**KIRKLEES METROPOLITAN COUNCIL
INVESTMENT & REGENERATION SERVICE**

**DELEGATED DECISION TO DETERMINE APPLICATIONS FOR
CONSENT, AGREEMENT OR APPROVAL REQUIRED BY CONDITION**

Reference No:	2023/44/93276/W
Site Address:	Hey Knowle Farm, Linfit Lane, Linthwaite, Huddersfield, HD7 5LF
Description:	Discharge conditions 3 (materials), 4 (improvements to access track and parking), 5 (waste collection) on previous permission 2021/94676 for erection of extensions and alterations to convert existing pig sty, domestic storage and WC building to single dwelling
Recommending Officer:	William Simcock

Officer Report 2023/93276

title Site plan and location plan
number 20141D-05-P04
scale 1:200, 1:100 and 1:1250
size A1

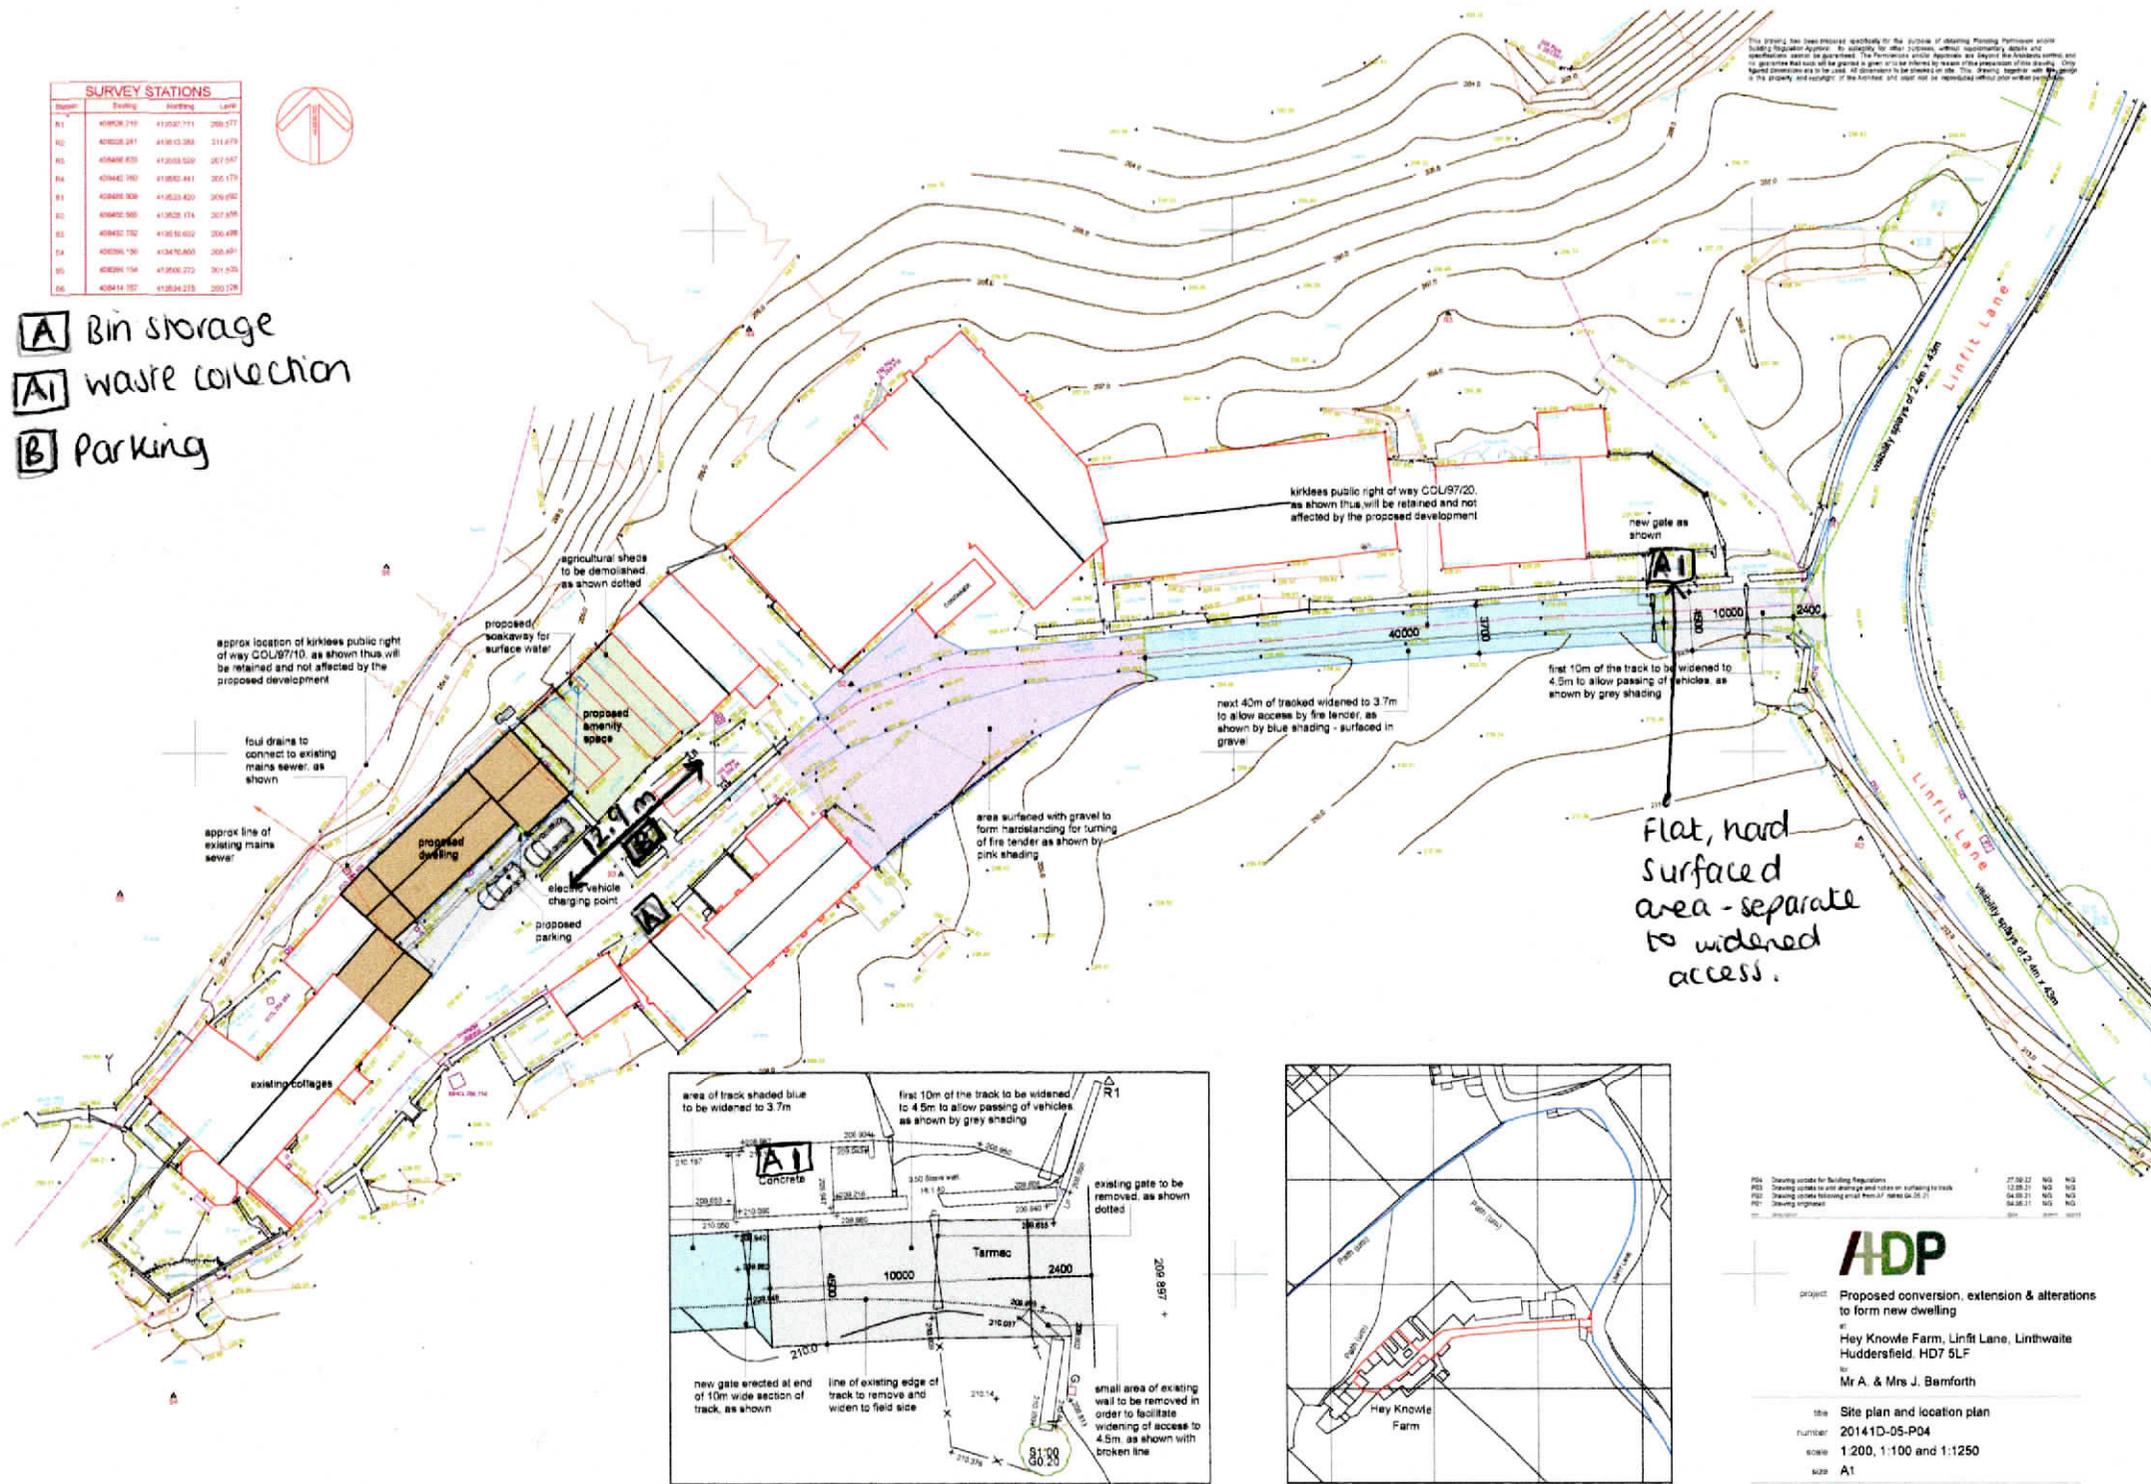
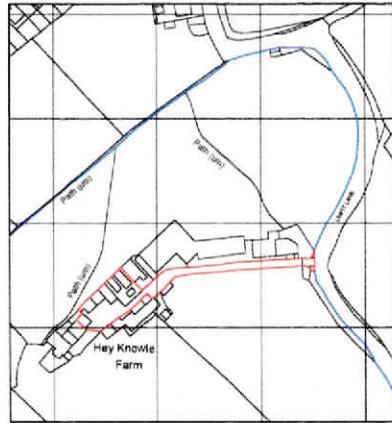
The supporting statement and plan 20141D-05-P04 indicate that:

- The lane will be widened, excavated to a depth of 650mm, then filled with sandstone hardcore and finished with compacted tarmac plainings.
- Cars to be parked as shown at points B on adapted site plan showing in a black line that the removal of a temporary shed has made space for two car parking sites adjacent to the proposed amenity space.

The views of Highways Development Management (HDM) have been sought. Their response is still awaited but is expected to be forthcoming soon. This condition cannot be discharged at the present time until comments have been received from HDM.

The site plan shows three squares, sketched on in black pen, one labelled 'A' and two labelled 'B'. The supporting statement claims that waste bins, both green and grey, will be stored and collected from point 'A' on the adapted site plan 20141D-05-P04 as per the waste bins from Hey Knowle Farm and Hey Knowle Farm Cottage.

The case officer has discussed these arrangements with the Waste Operations Manager who has stated that bin collection for the existing dwelling is from the site entrance, and has advised that it is unlikely, in view of current standards and practice, that bin collection crews would be able to collect from point 'A' or 'B' as shown on the plans.

This condition cannot be discharged at the present time.

The squares indicated 'B' are however deemed acceptable as bin storage points for the two new dwellings.

It is therefore recommended that the plan and supporting statement be amended to show:

- The two areas marked 'B' designated as bin storage points for the new dwellings.
- The bin collection point on the access track just in from the junction with the adopted highway so that it does not obstruct the highway but is easily accessible.
